CONSTRUCTION PLANS  
FOR  
**SKYLINE AT LORSON RANCH FILING NO. 1**  
STREET AND STORM SEWER  
CONSTRUCTION PLANS

SKYLINE AT LORSON RANCH FIL. NO. 1  
STREET AND STORM SEWER  
CONSTRUCTION PLANS

SF-22-001

STORM LATERAL 'B' (PUBLIC)

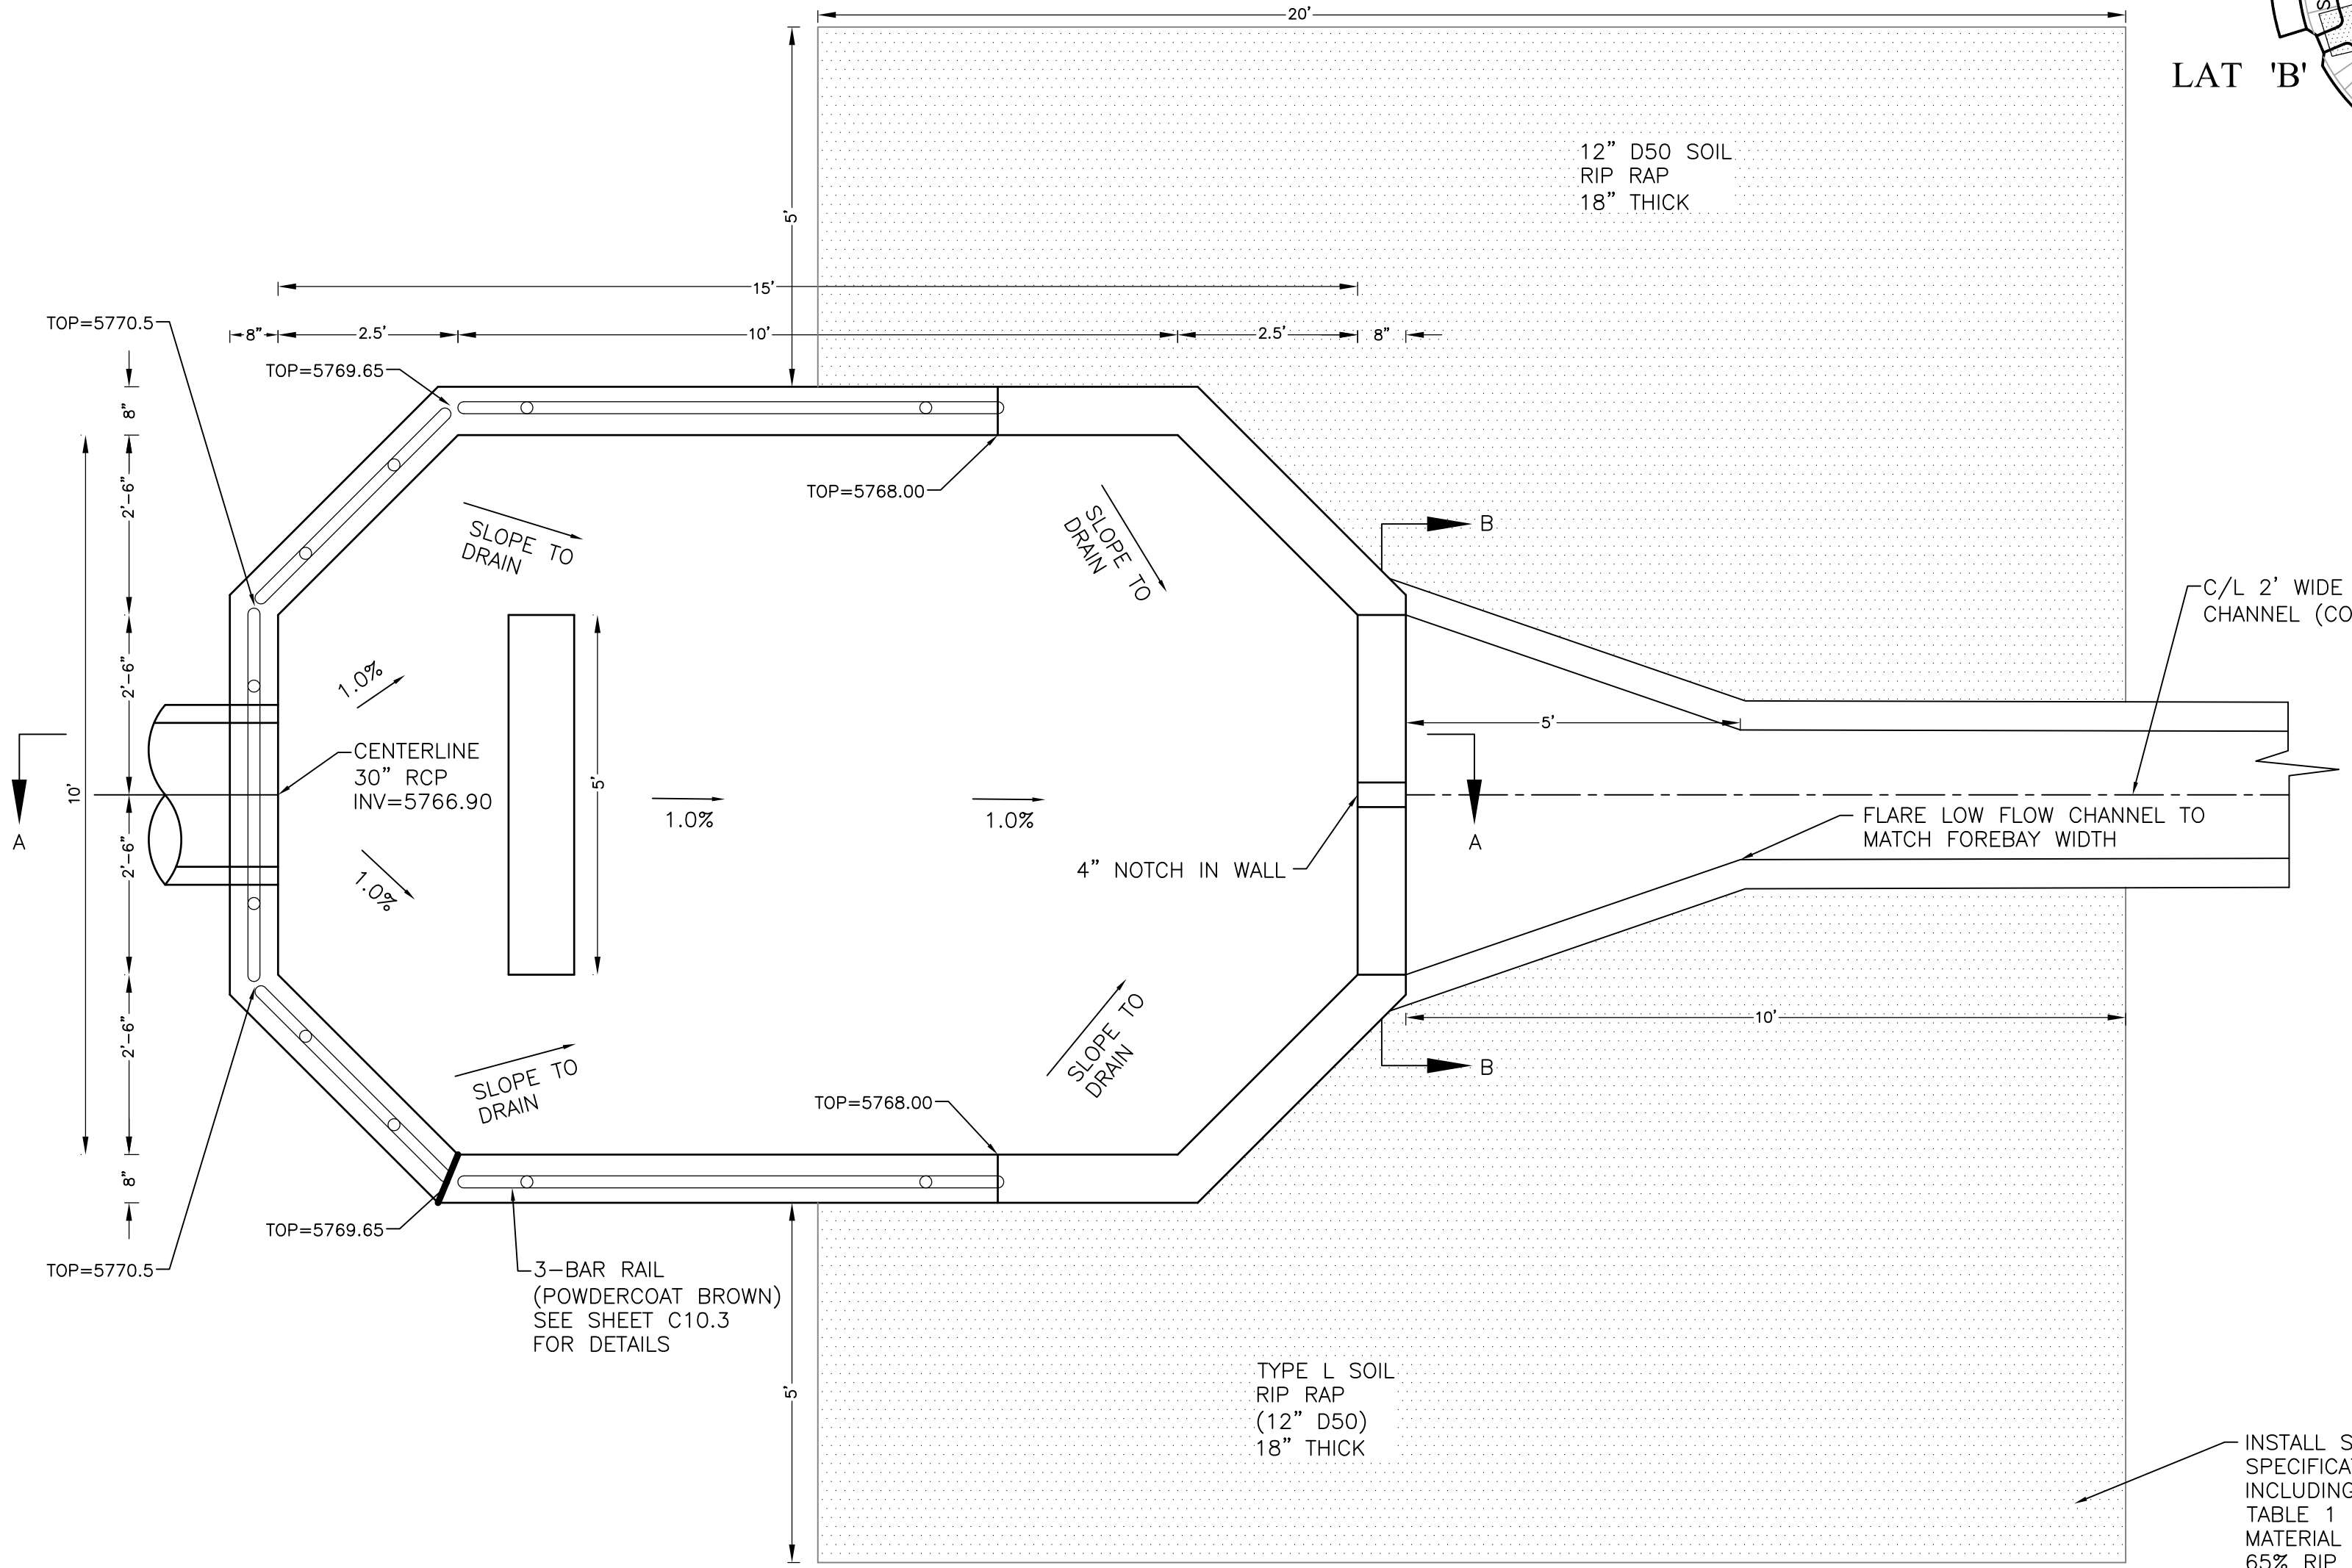
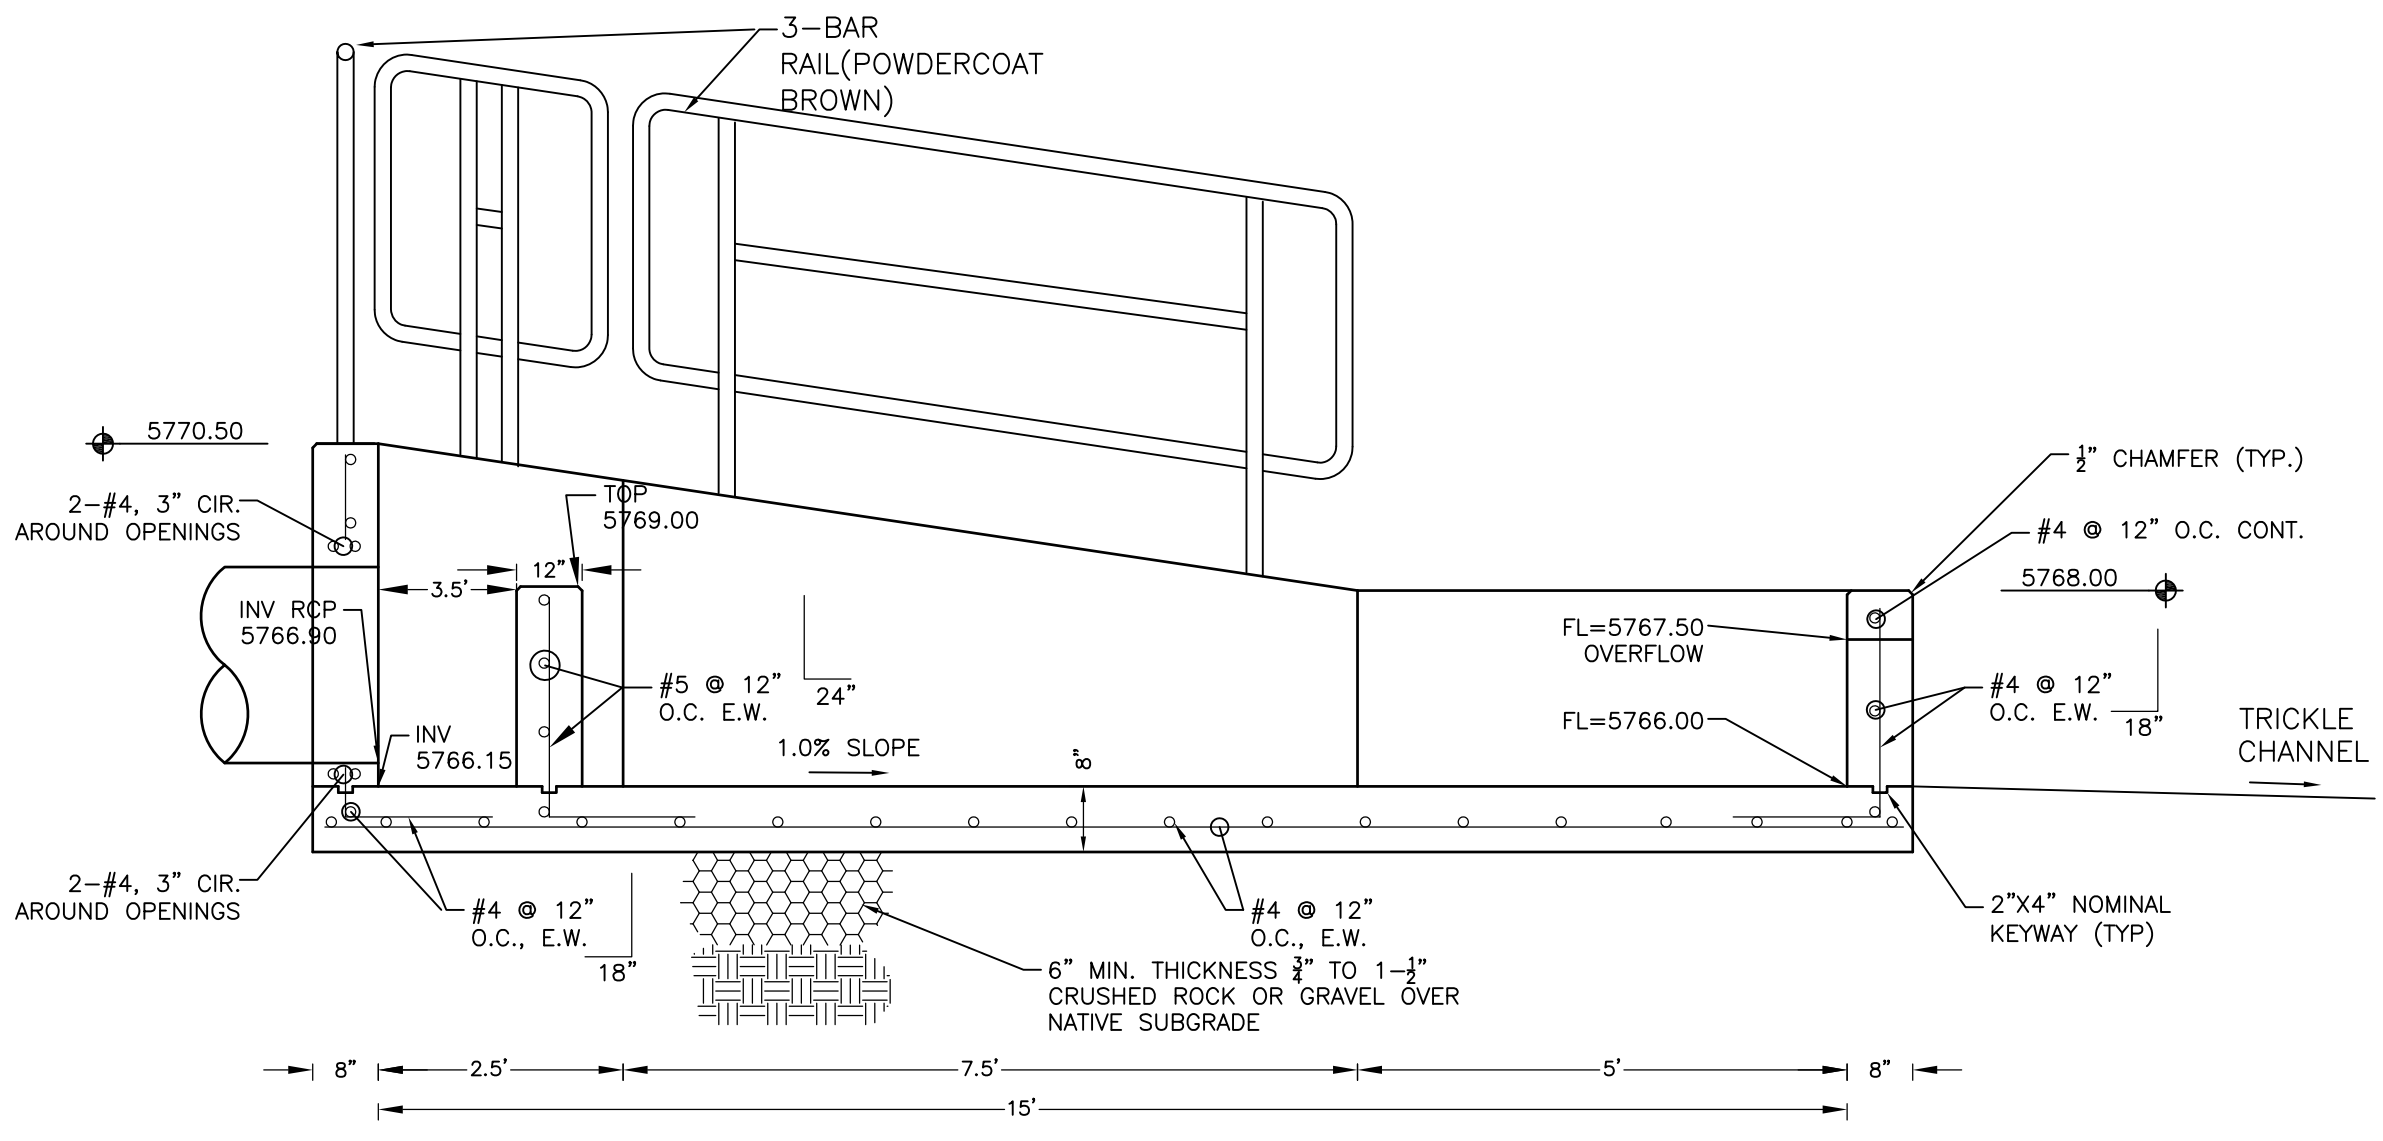
Label all storm facilities as public or private

STREET - STORM
GARGANEY DRIVE
STA 0+00 TO 6+50

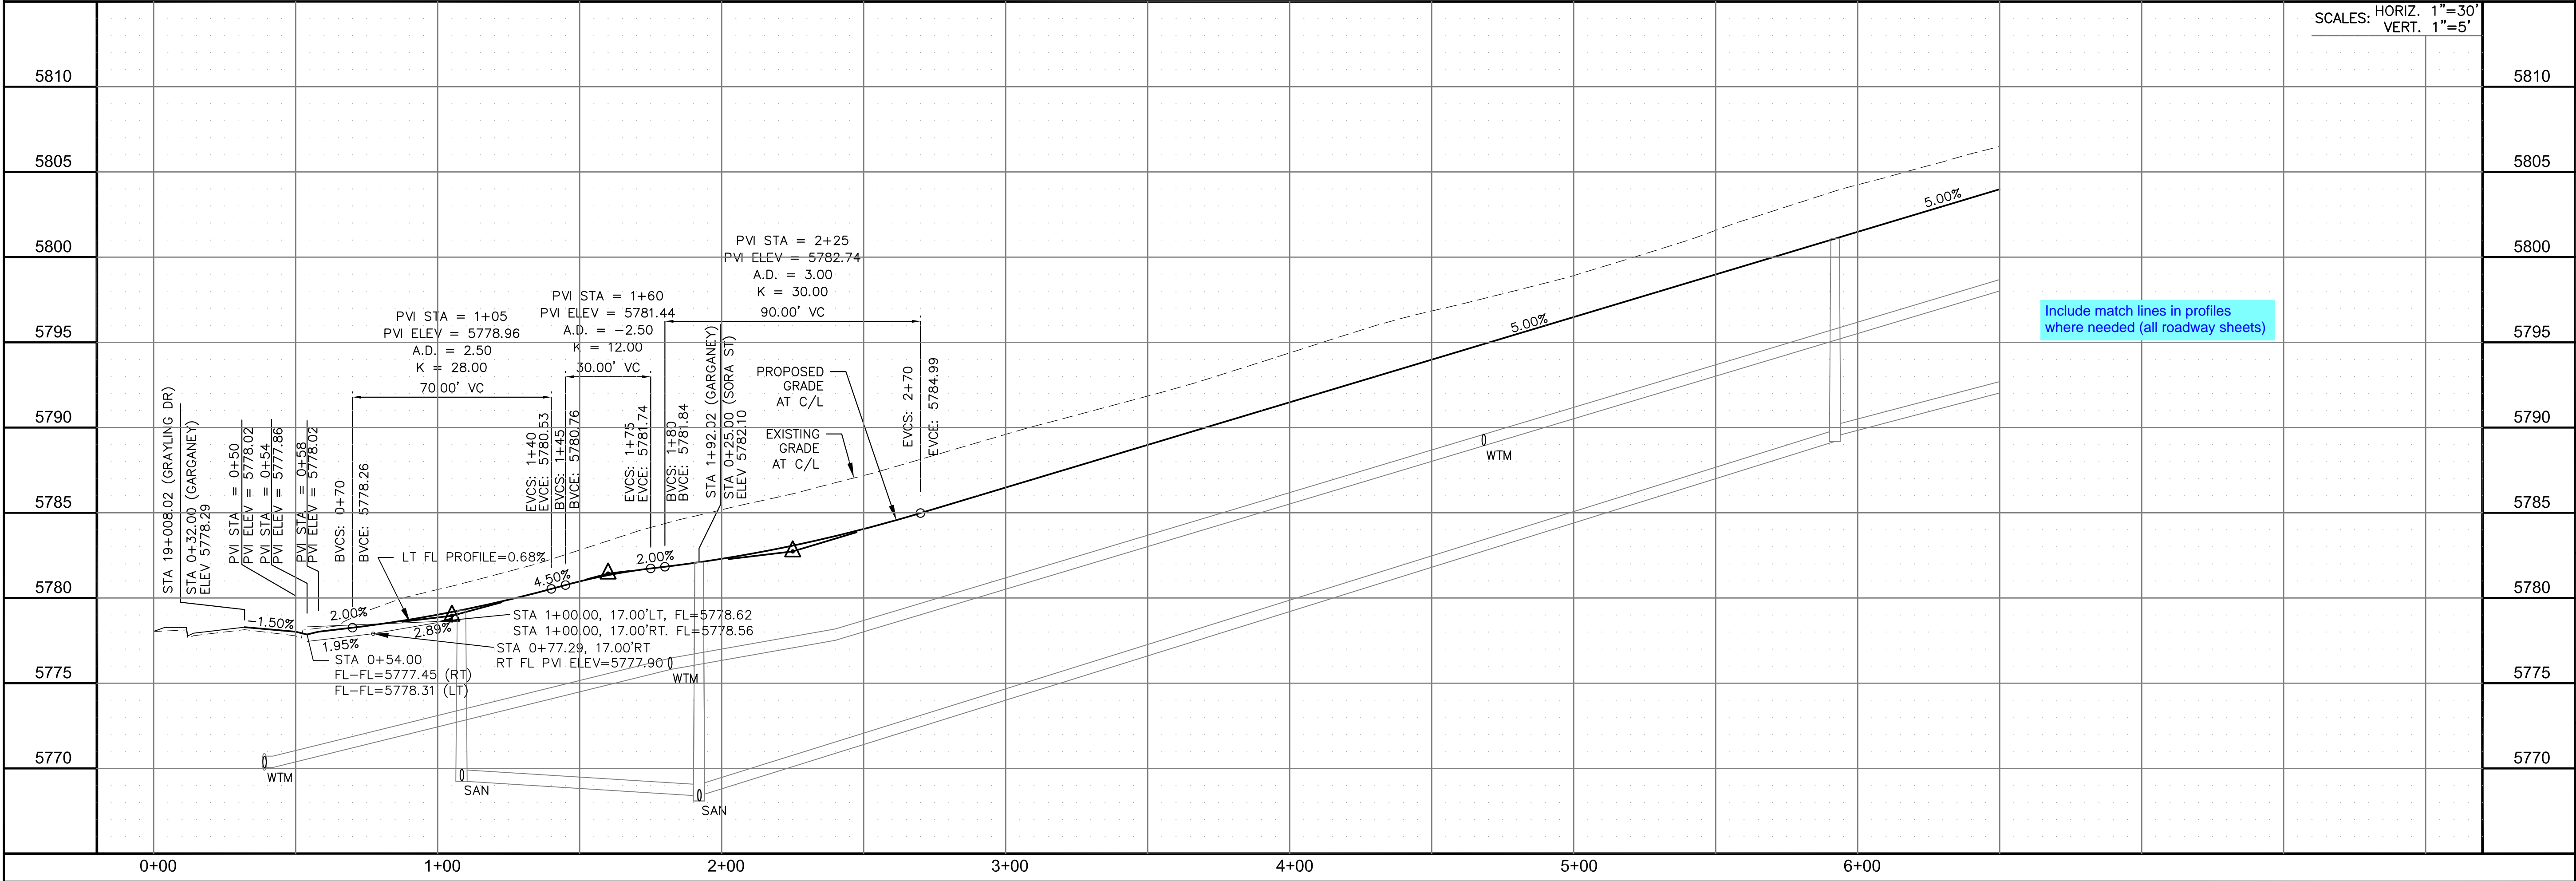
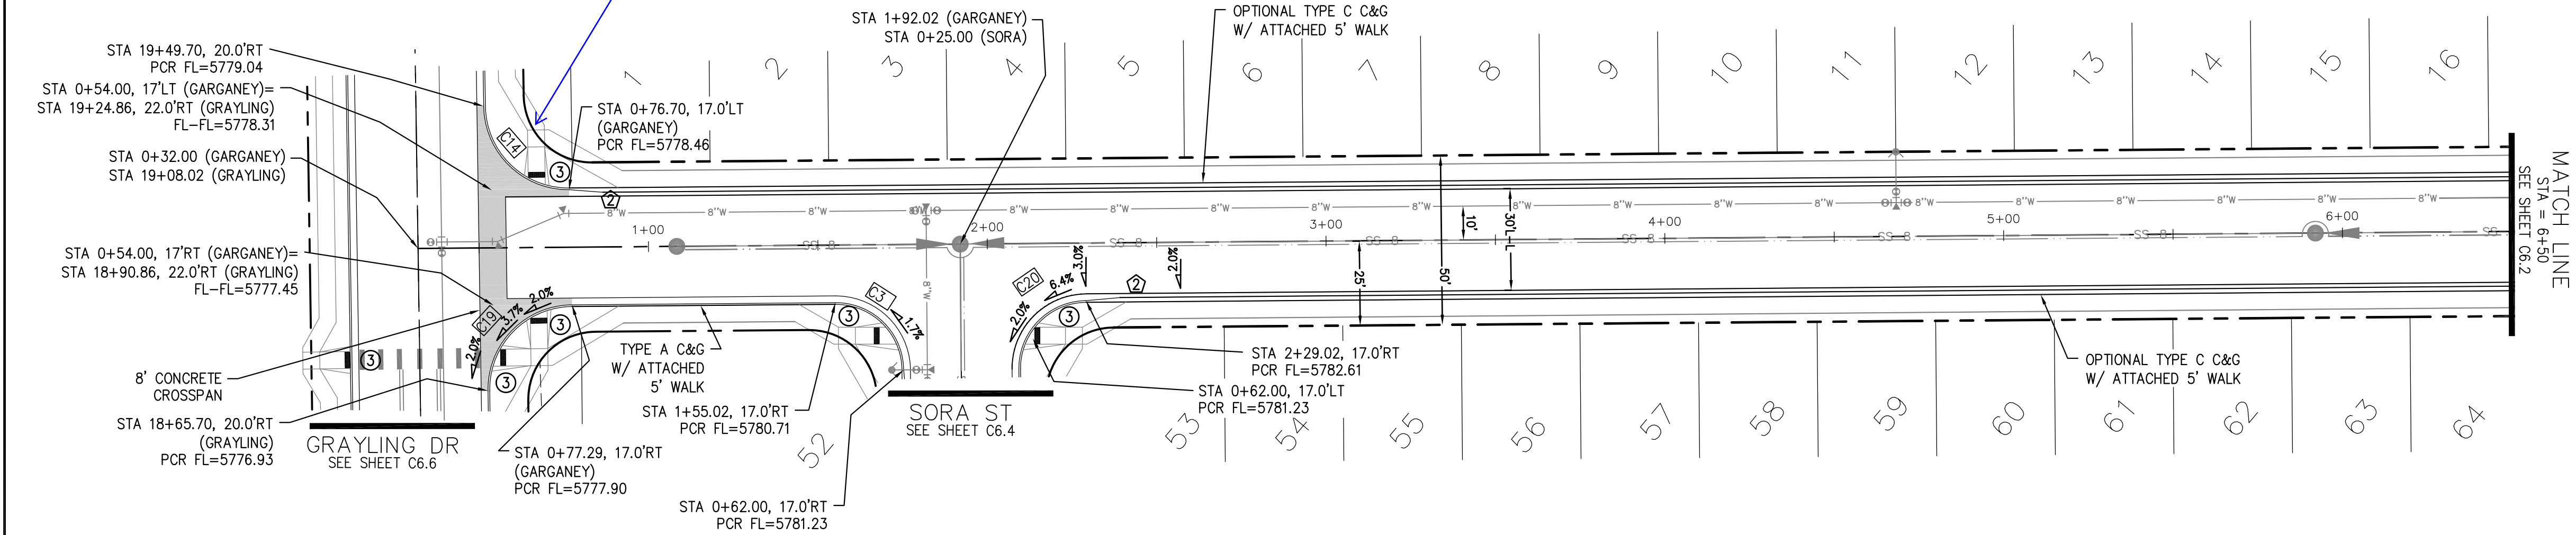
Include match line (same as in layout view)

Include Match line (same as in layout view)
